## **Response to Application No. 2023/62/91649/E – OBJECTION**

**We would like to lodge the STRONGEST OBJECTION to this application on the following grounds:-**

Tree Constraints Plan
11 Wood Street, Skelmanthorpe

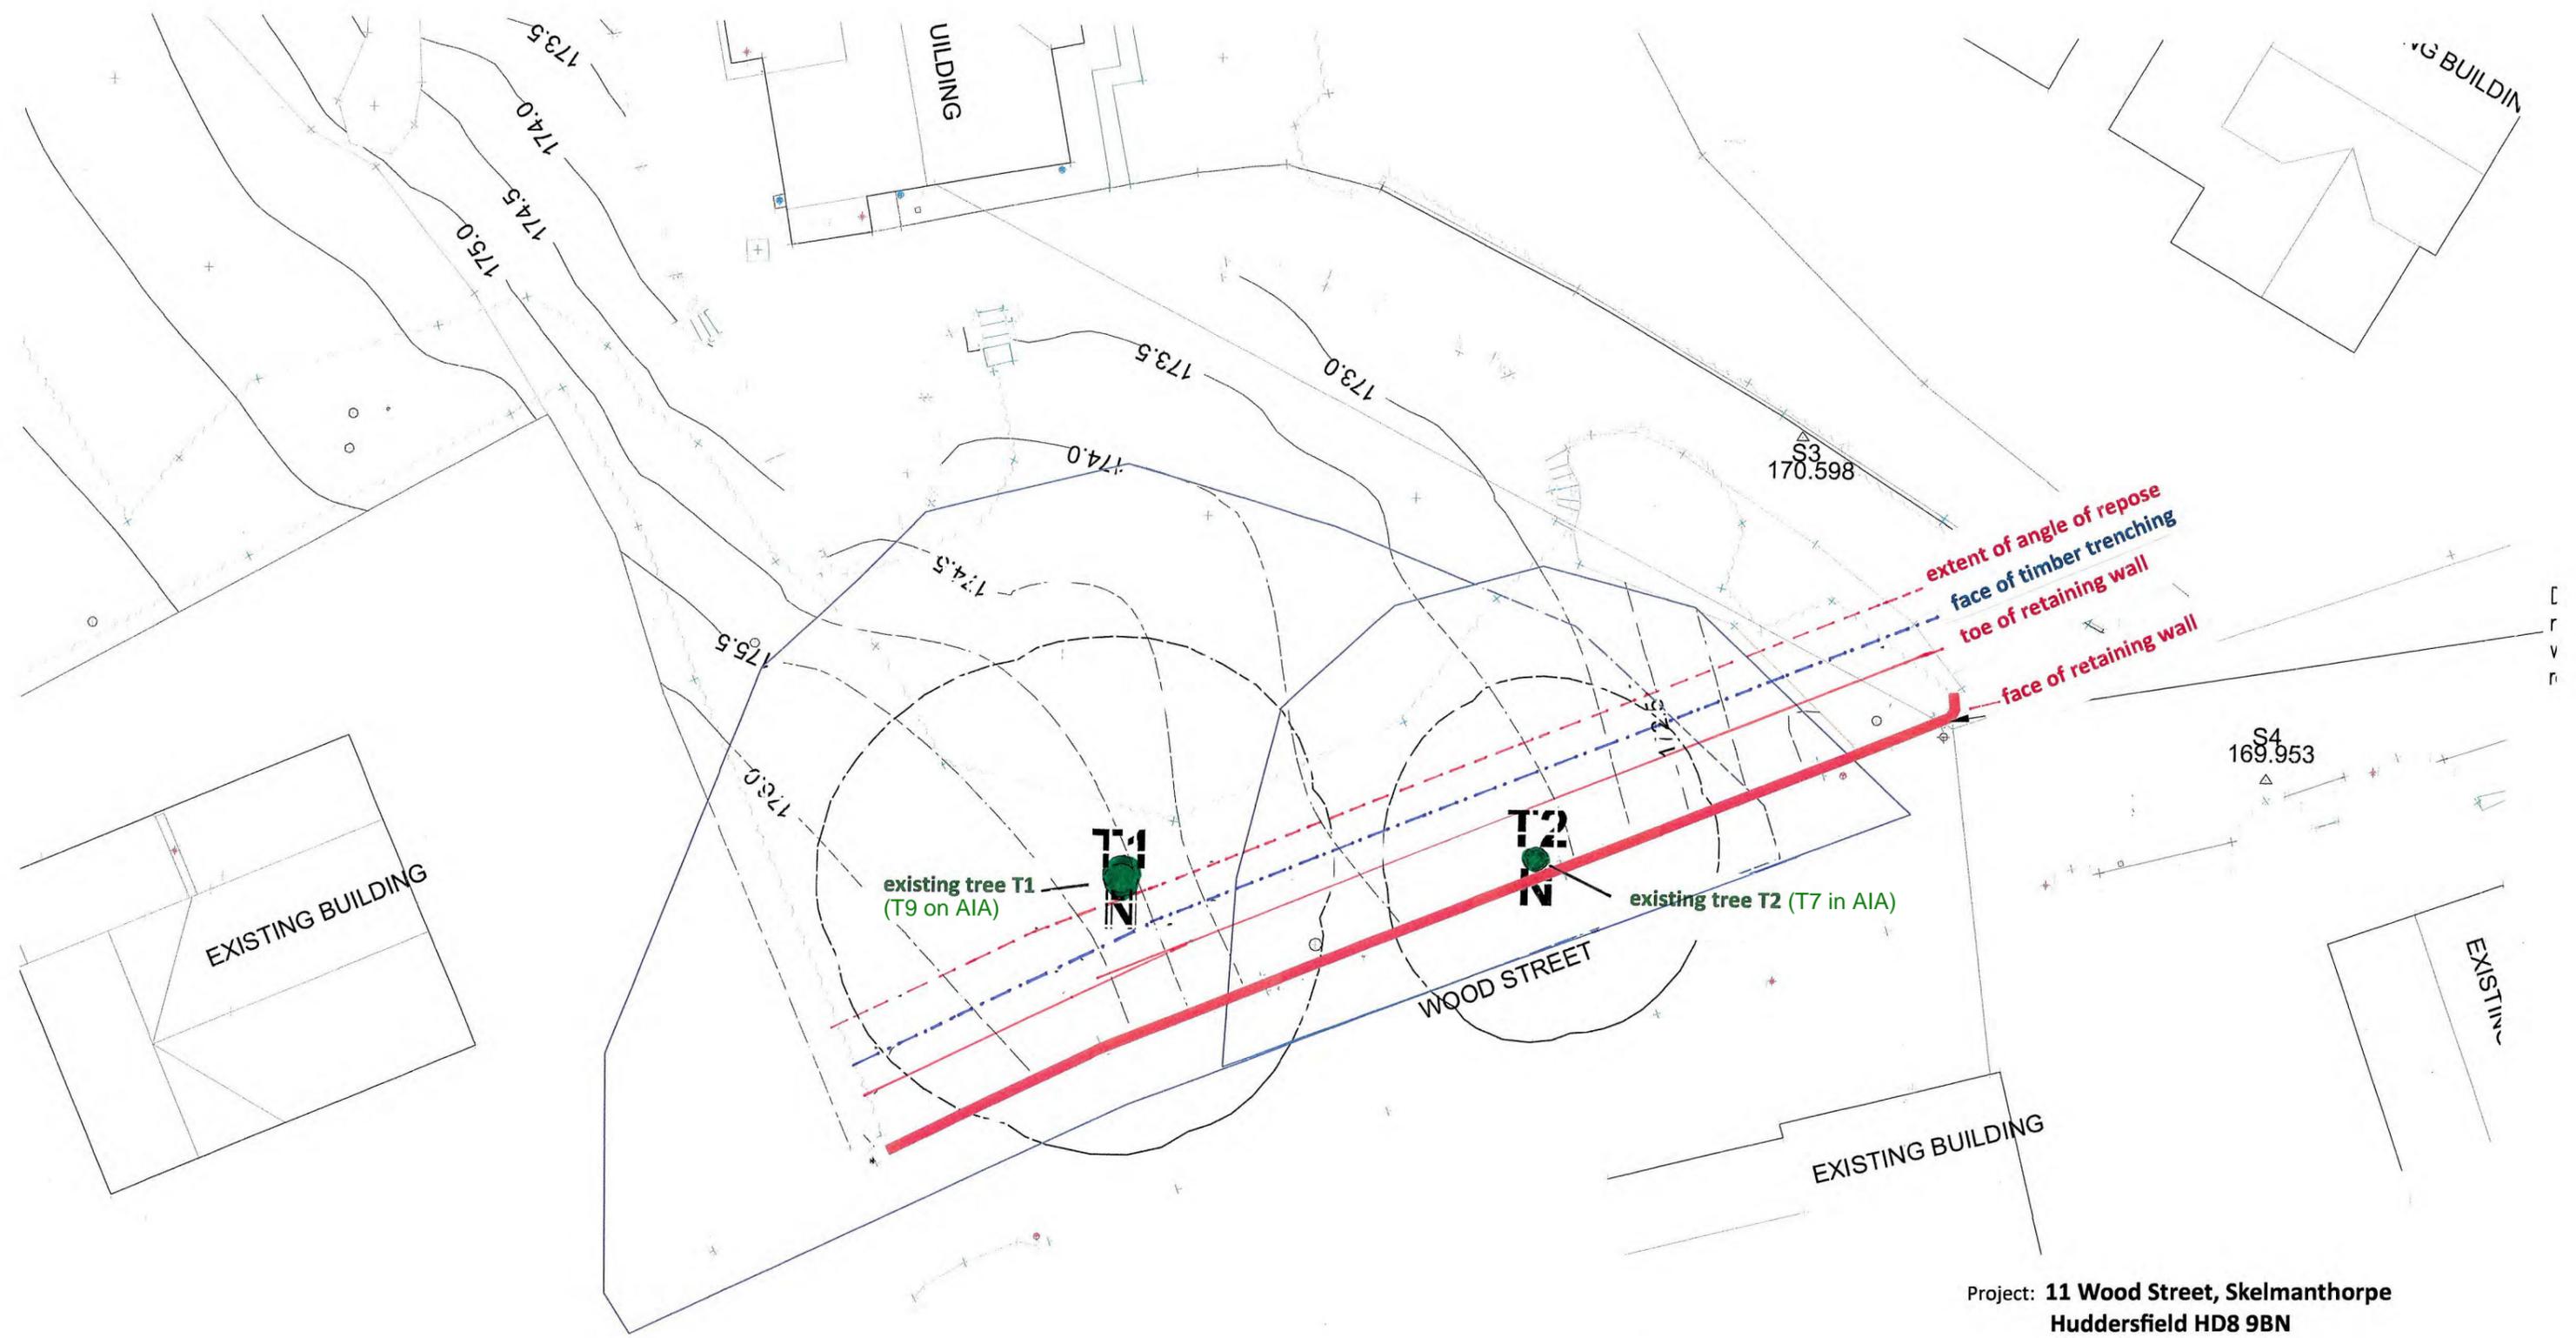
- **It involves not only the destruction of two TPOs but the entire row of mature trees which fringe the Conservation Area. We seriously question why all the row of trees are not TPOs, given the trees on the LHS of Wood Street are so and they fringe the Conservation Area boundary line.**

- These trees which also extend up the western boundary of the site, support a wide range of wildlife and biodiversity – birds, squirrels, owls, bats and amphibians are present. They form a natural corridor for nature.

Drwg No: **SB/104**

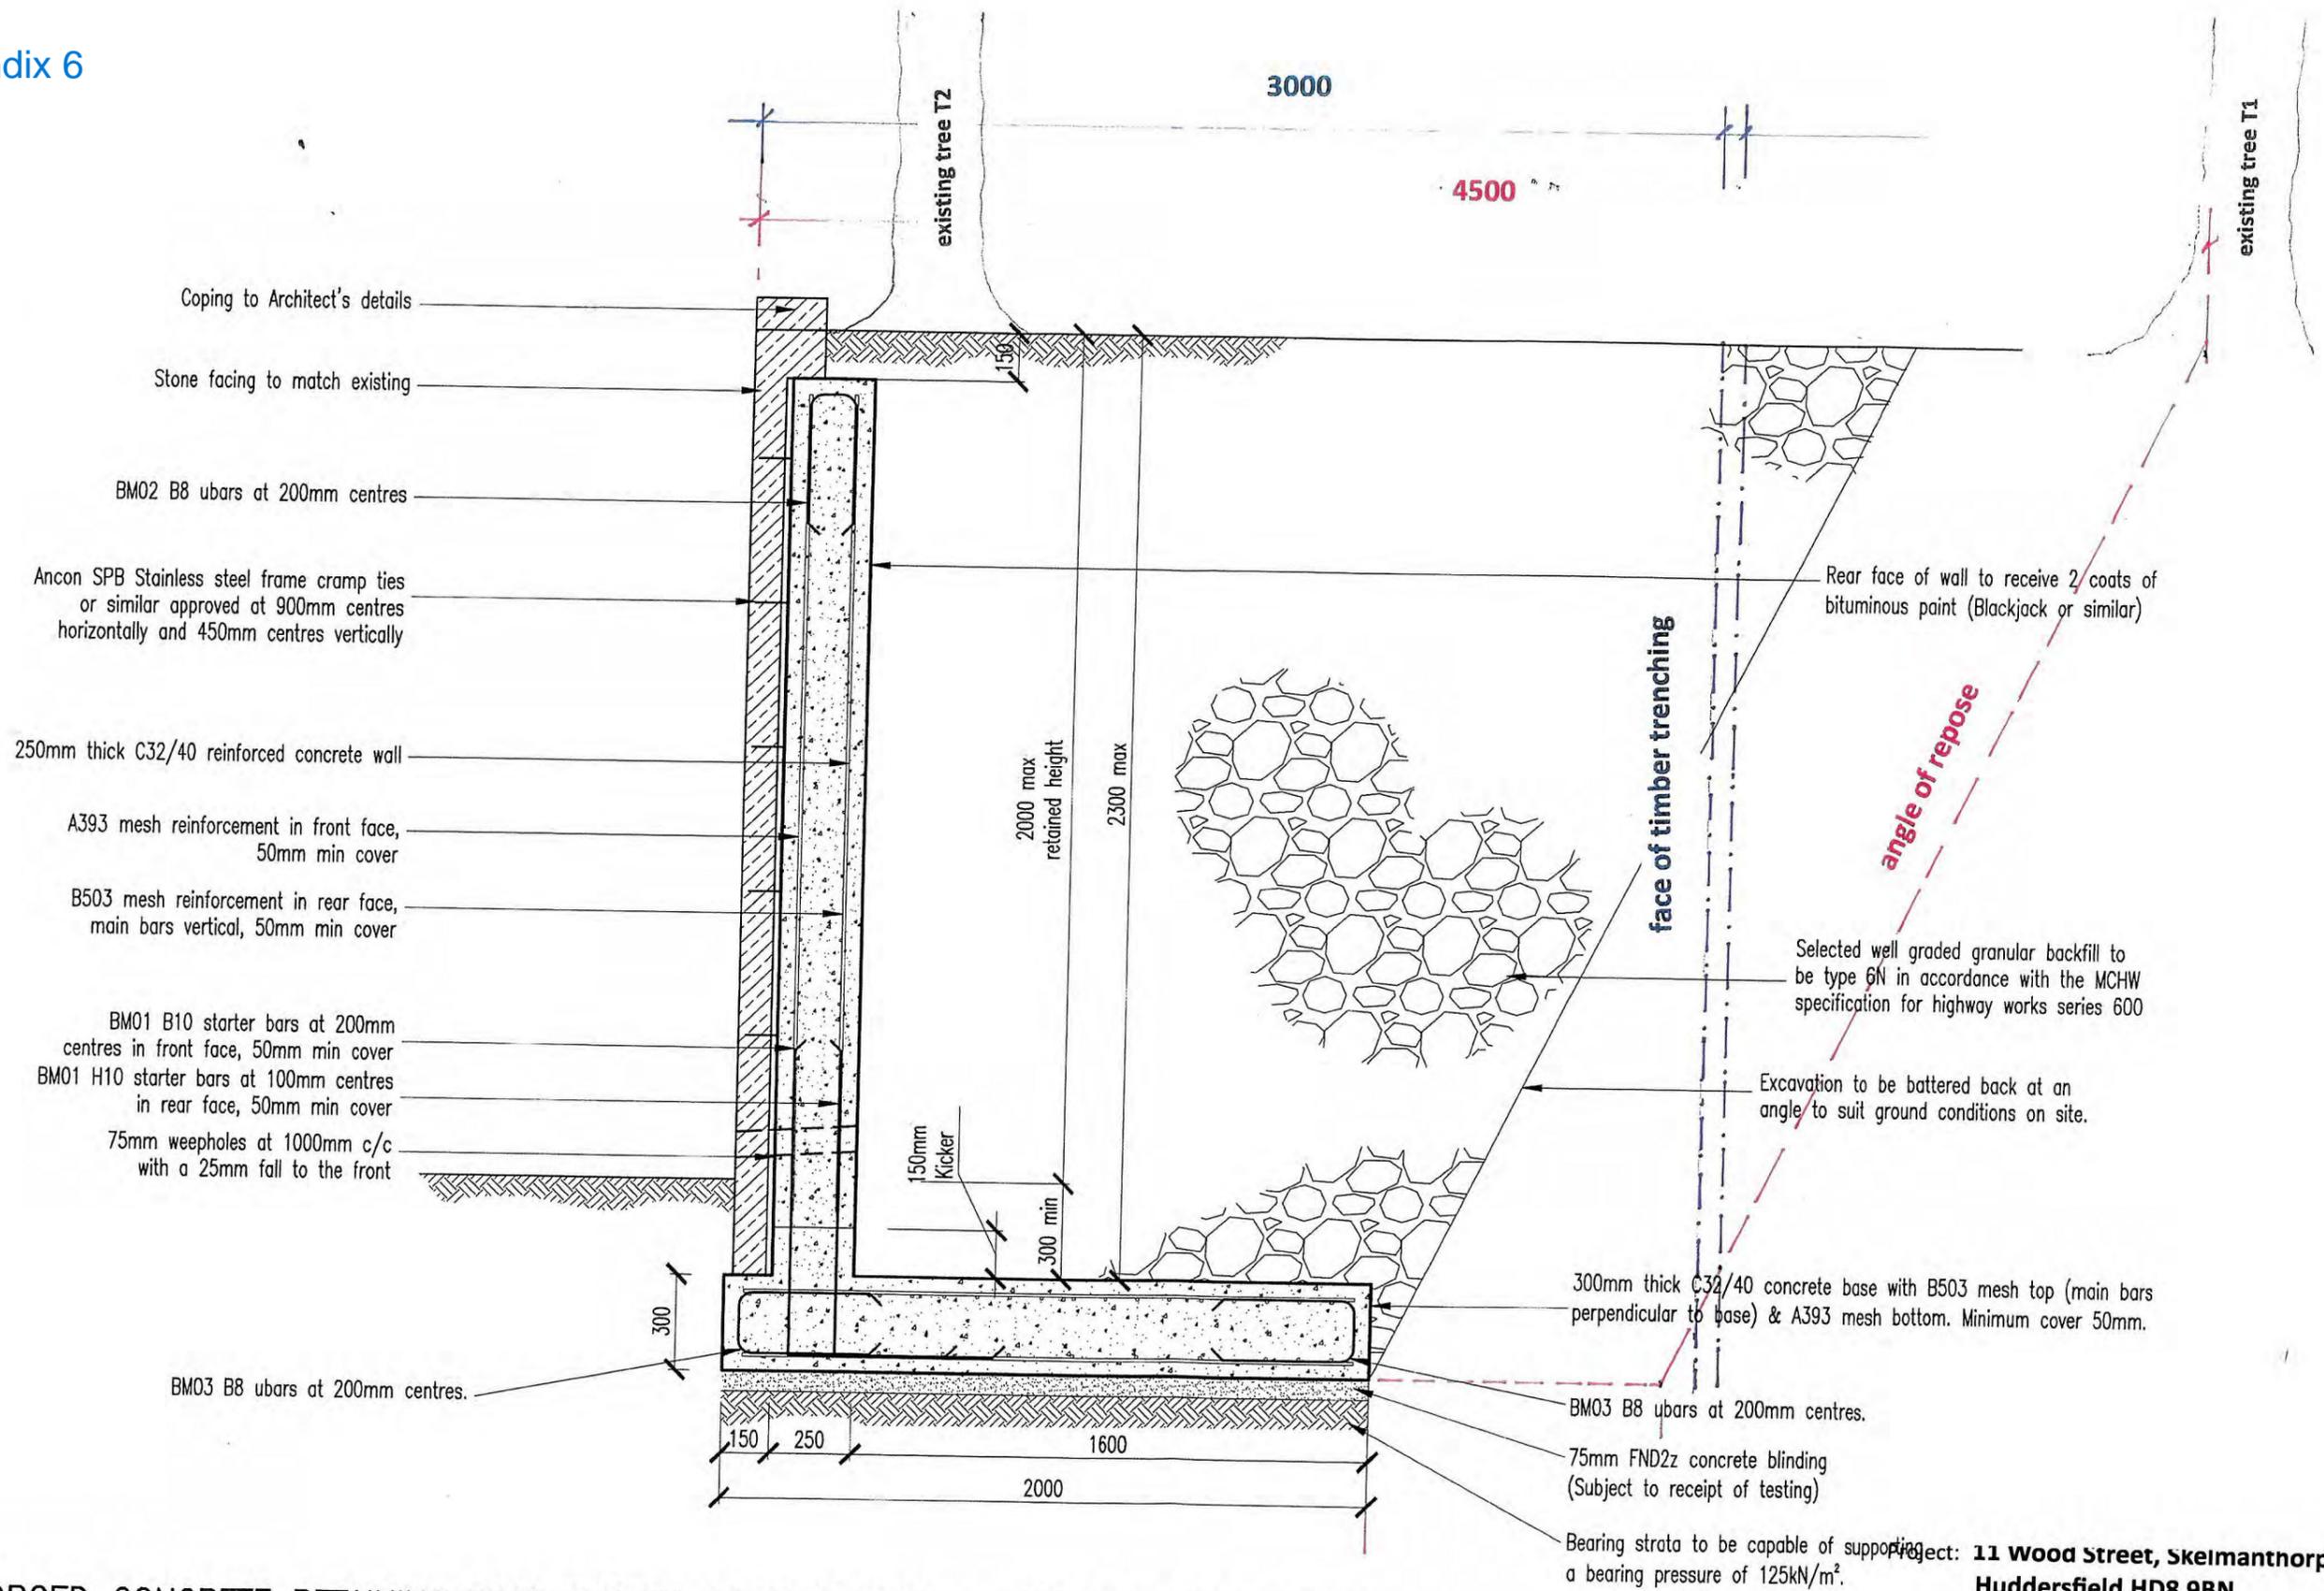
- The wall is generally in good condition and in keeping with the Conservation Area, apart from a small section near the driveway to No.11 Wood Street. The latter is bulging in this area only. The application appears to purport that the entire length of wall is about the collapse. This is NOT the case. We note the Consultants have only performed a perfunctory, visual examination.

- Our view is that only the bulging area is in need of repair at present, preserving the trees. Kirklees Highways Structures should be instructed to carry out this work.
